From: Kathy Wilkinson [REDACTED]
Sent: 24 June 2019 19:50
To: Planning <Planning@arun.gov.uk>
Subject: Planning FG/59/10/HH

Development: Erection of Single Storey extension to East elevation and First Floor extension

Location: Pied at Terre, Ferring Street, Ferring

Proposed First Floor Plan

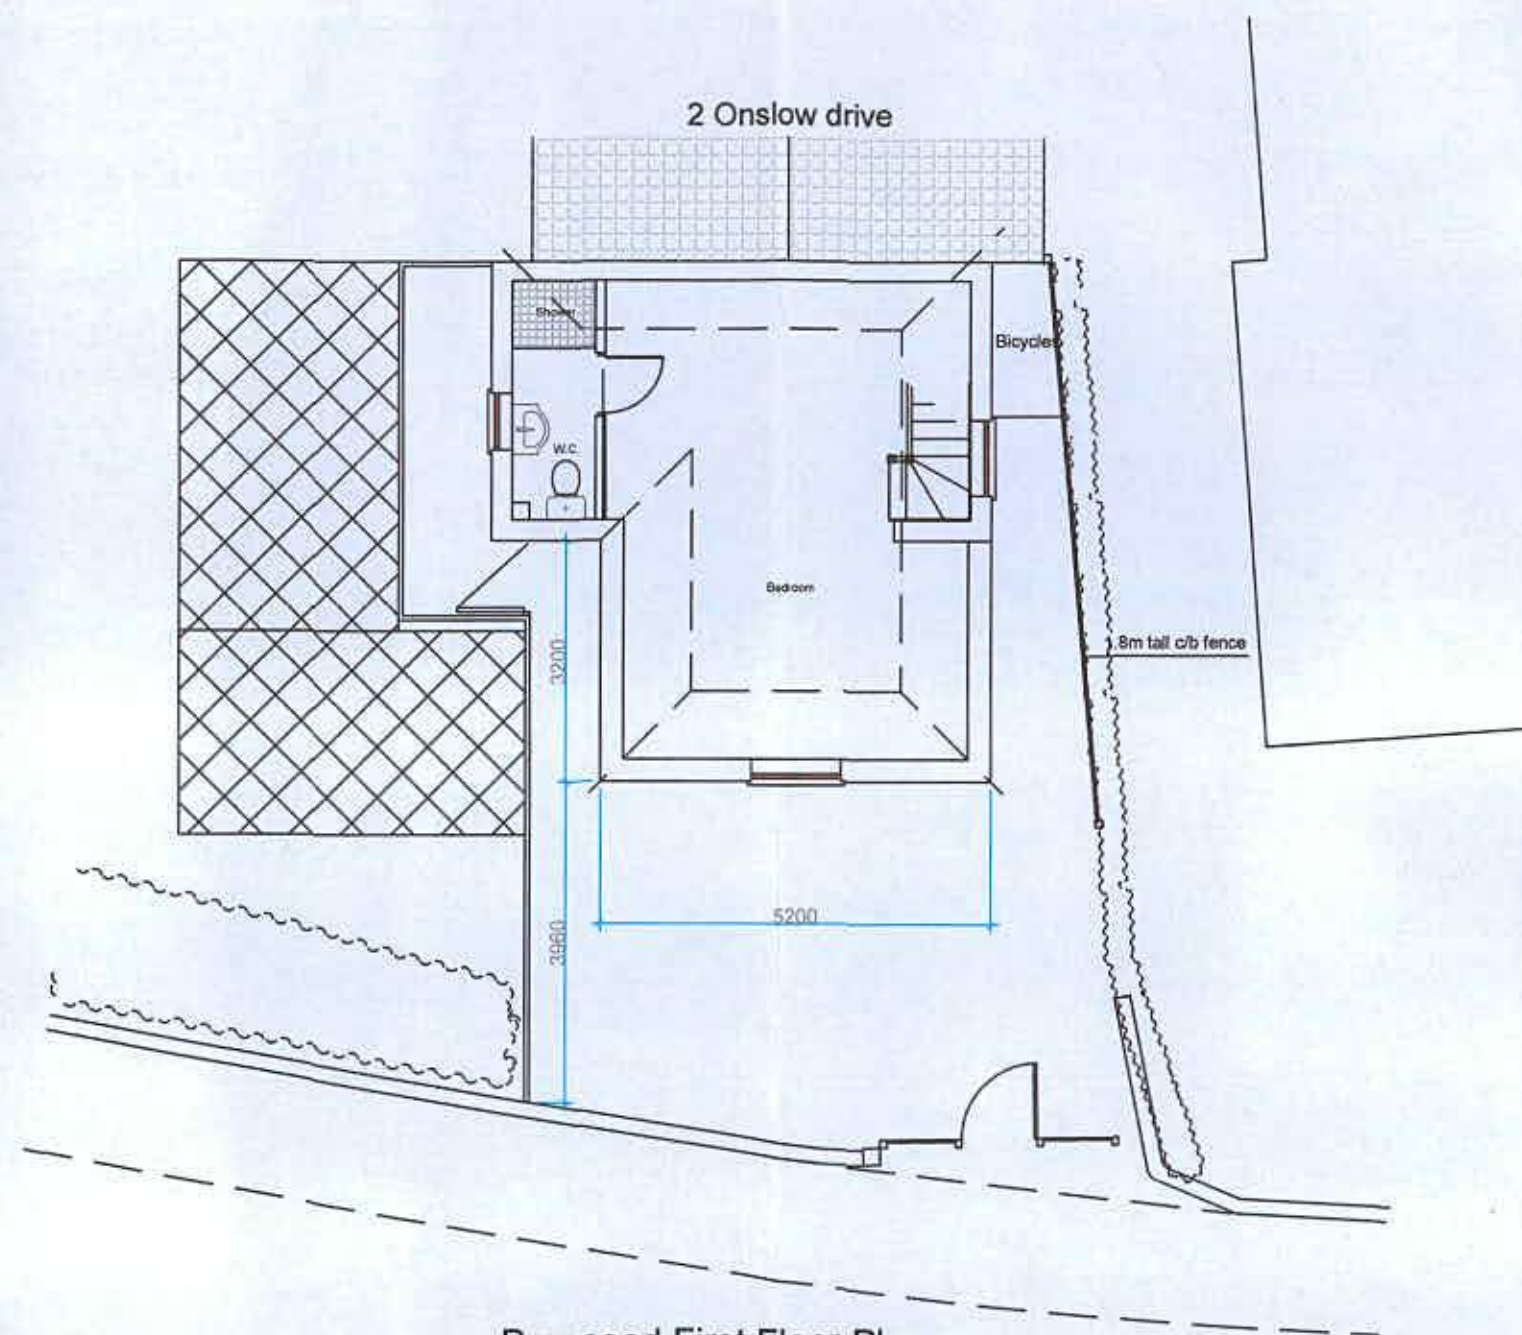
I wish to object to the above proposed development because I am concerned that the extended first floor will:

1. Cause loss of sunlight to my south facing window creating a darker kitchen and bathroom
2. Present a close blank wall from my window as the immediate view less than four metres from my south facing window rather than onto the unoppressive open forecourt view that currently exists
3. Cause a dominating and oppressive effect on my home
4. The block and roof plan shows the front roof line in line with the front of Pump Court and does not show the porch that projects in front of the building line, the proposed plans indicate the front wall in front of the building line
5. The trees and shrubs along the boundary between the two properties will be deprived of sunlight
